Transport  
for NSW

TfNSW Reference: SYD18/01609/03

Departments Reference: SSD 9653

## HILLS SHOWGROUND STATION PRECINCT CONCEPT PROPOSAL

Drawing Title
Road Hierarchy Plan

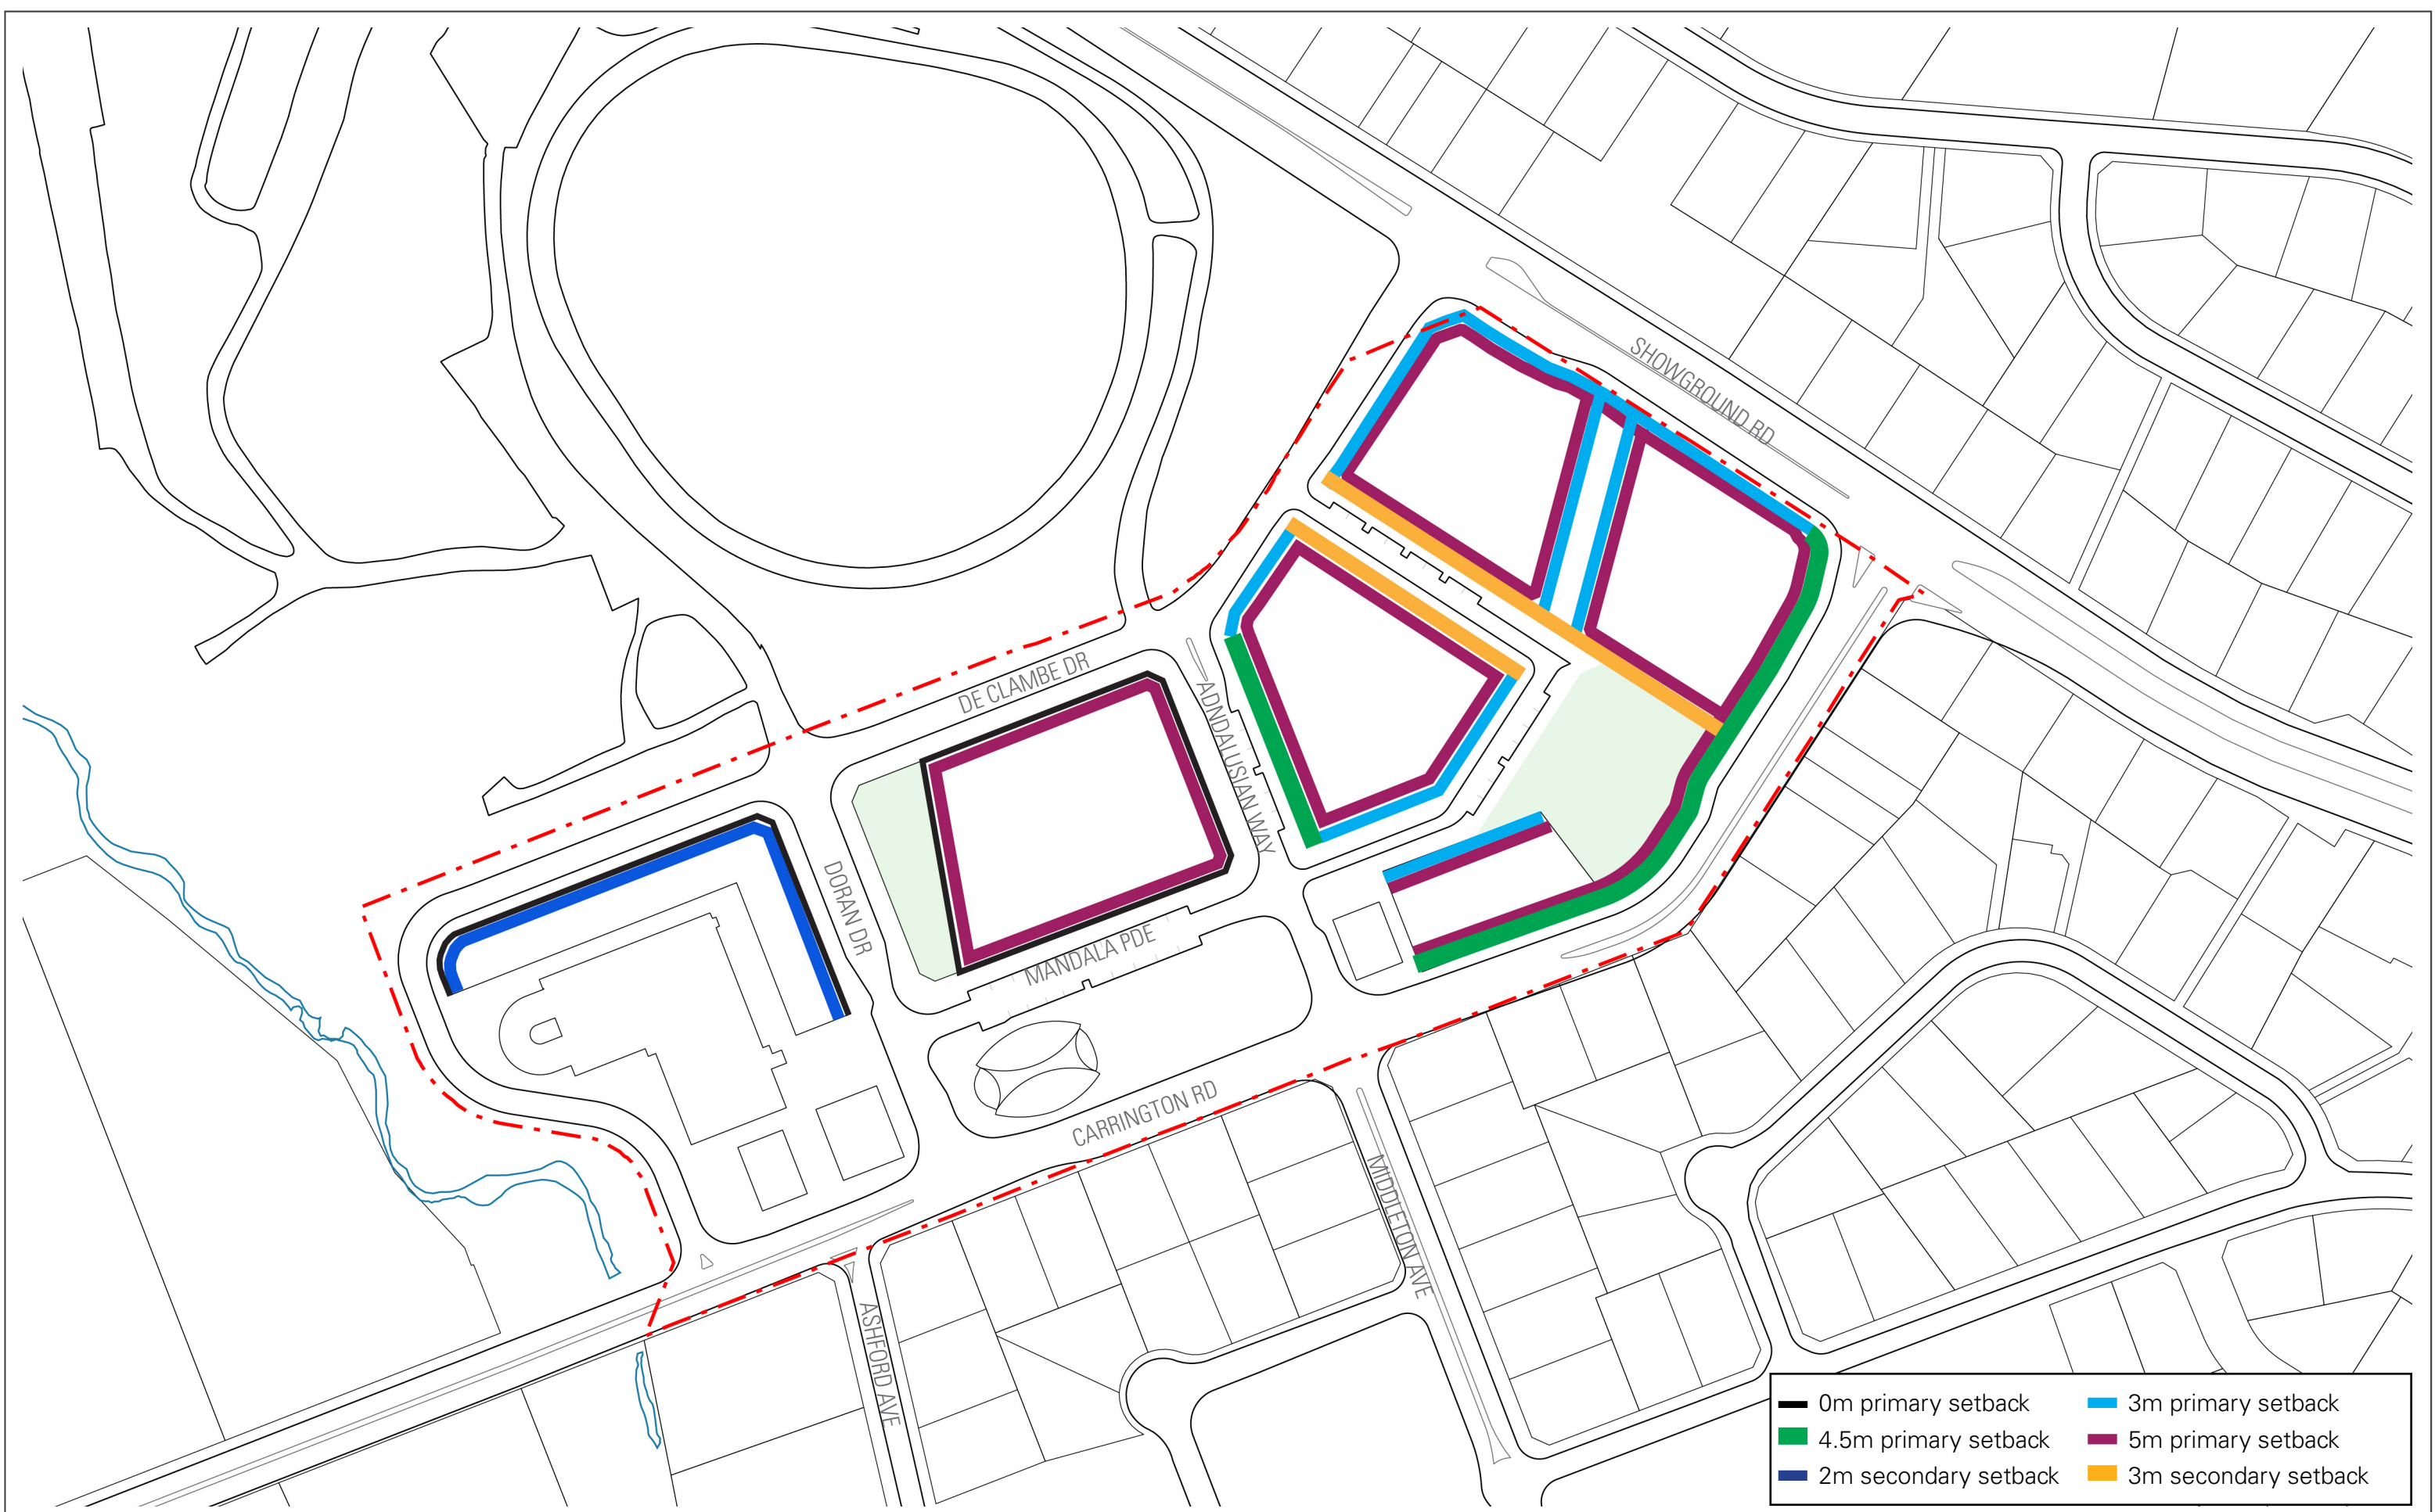
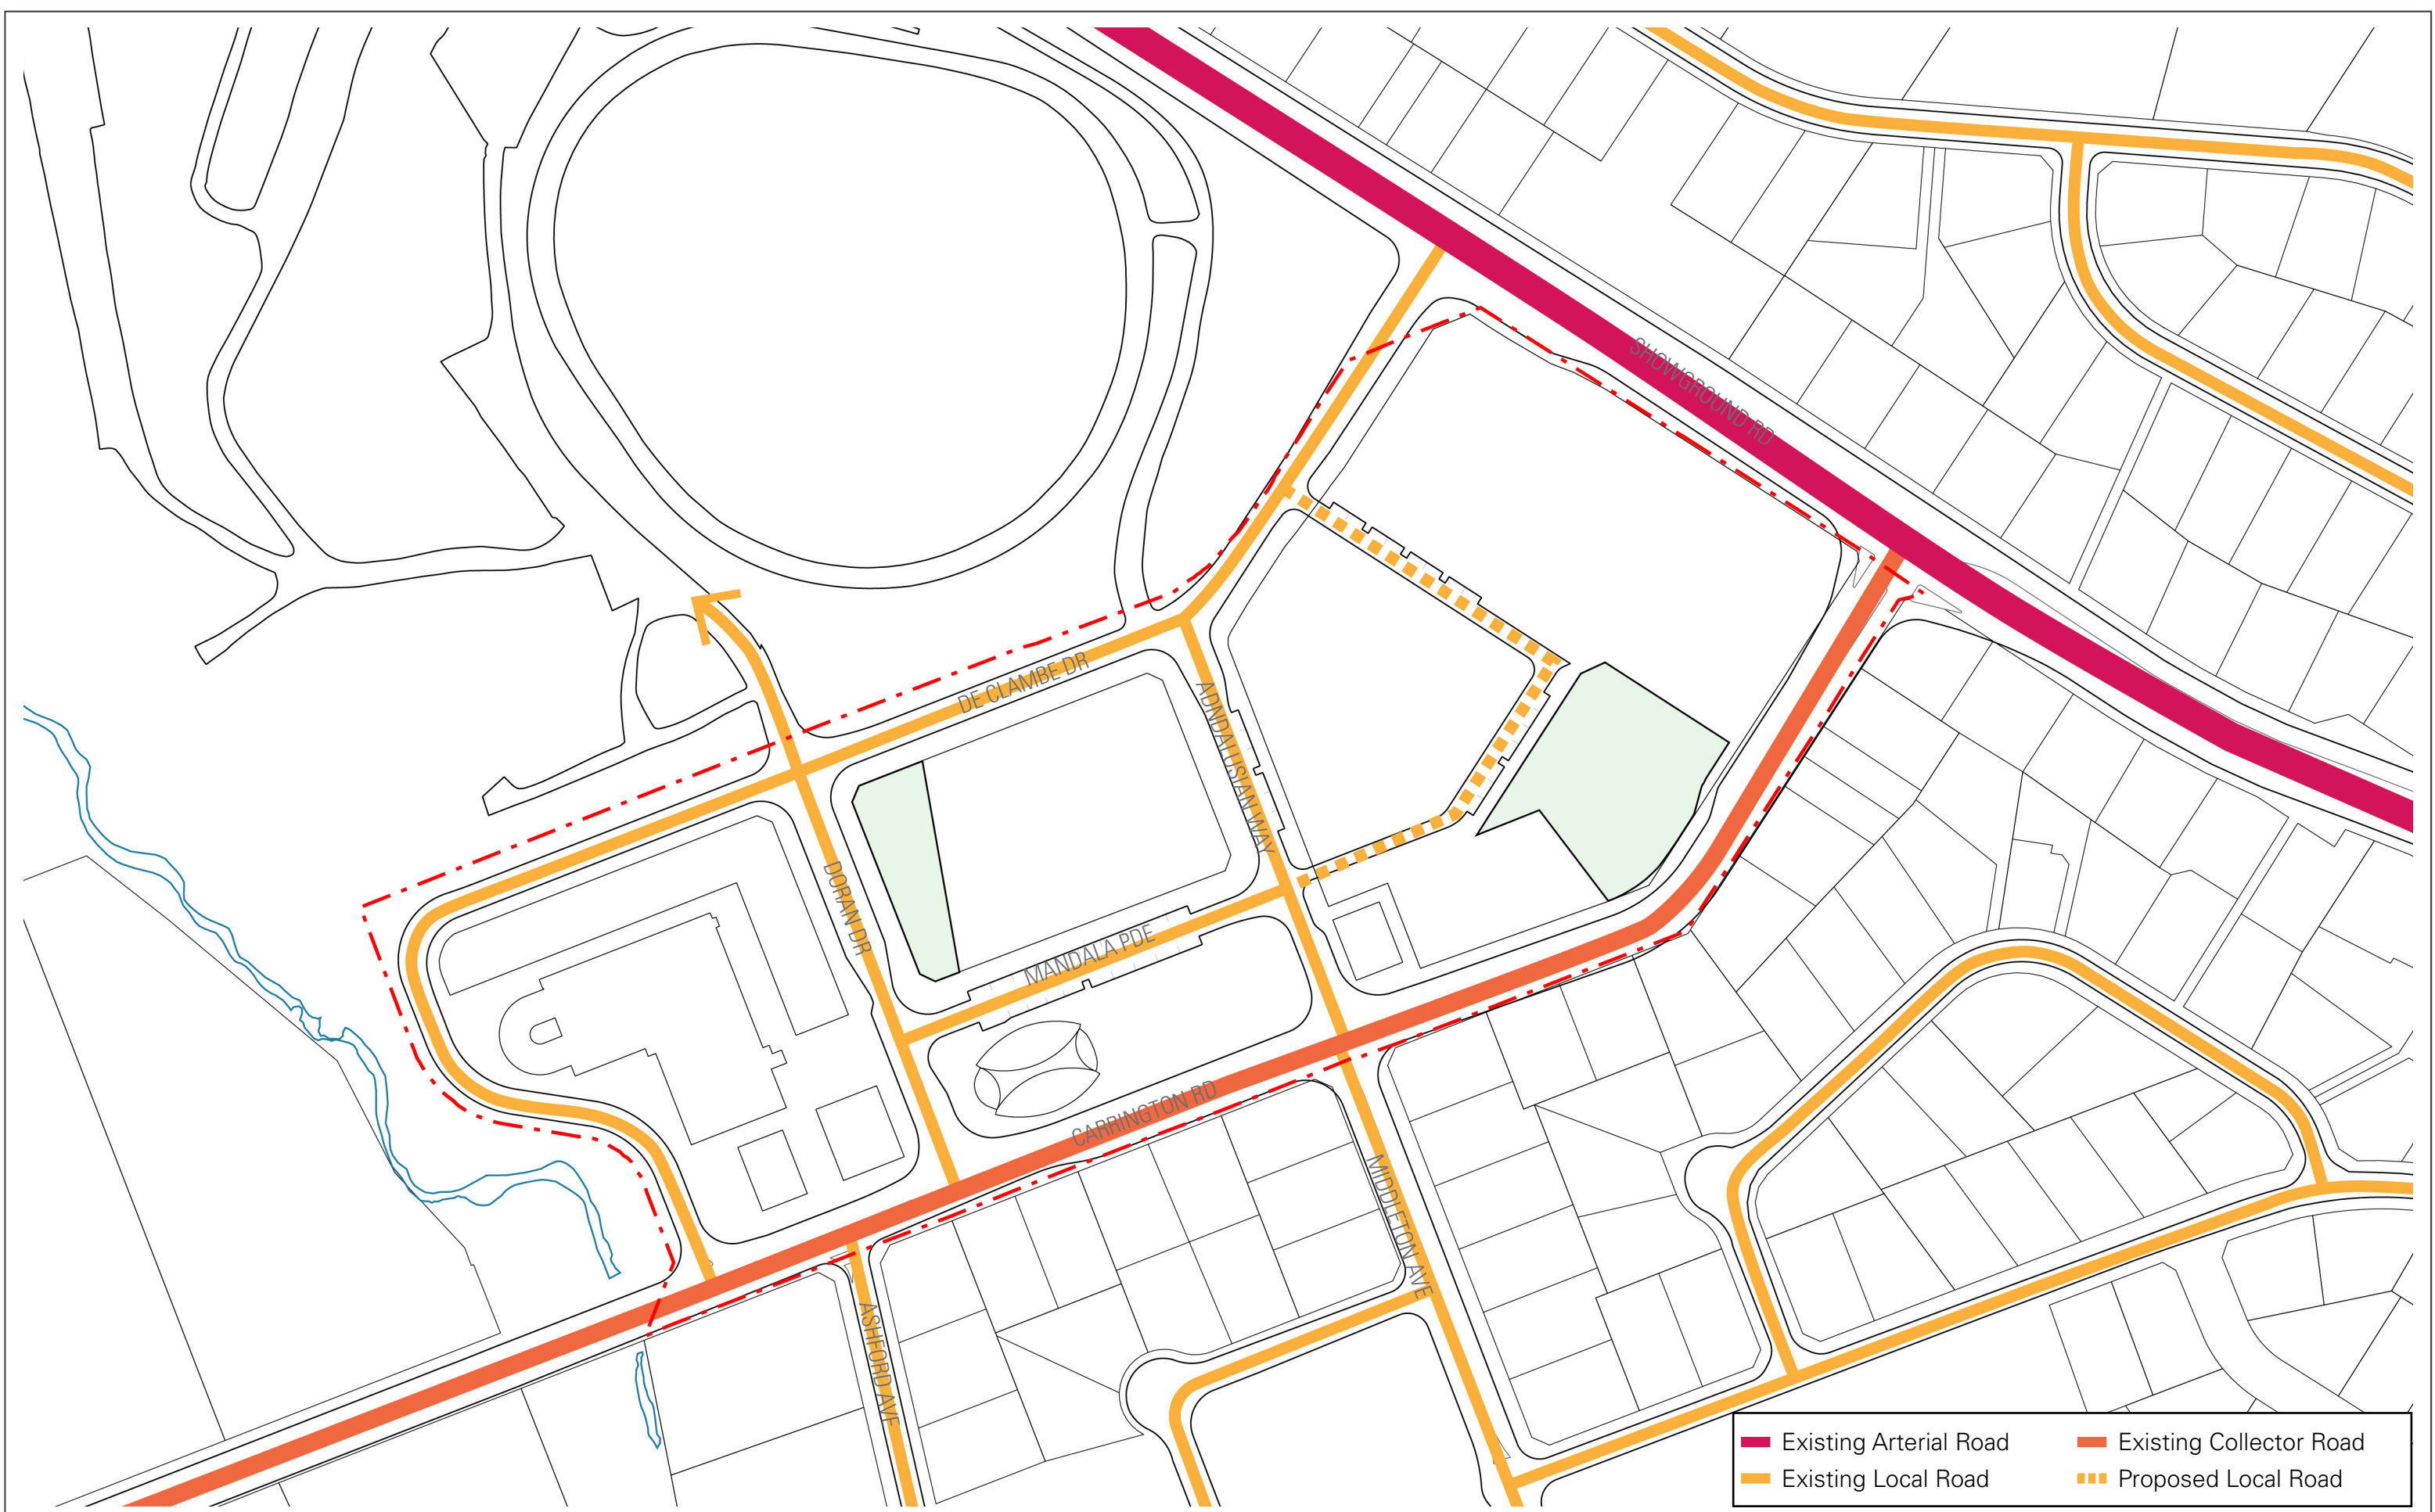
It is noted that the proposed building Set Backs identified within the Urban Design Report on Page 64 are inconsistent with/do not comply with the Building Set Backs identified within Figure 41 / 42 of The Hills DCP (2012) – Part D – Section 19 – Showground Station Precinct (see **Tab A**), particularly along Showground Road and part of De Clambe Drive. This has the potential to compromise any potential mitigation measures that may be identified as outcomes from The Hills Showground Station Precinct Traffic and Transport Planning Study (which is underway).

Therefore, it is recommended that the proposed building Set Backs associated with this SSD comply with the Building Set Backs identified within Figure 41 / 42 of The Hills DCP (2012) – Part D – Section 19 – Showground Station Precinct.
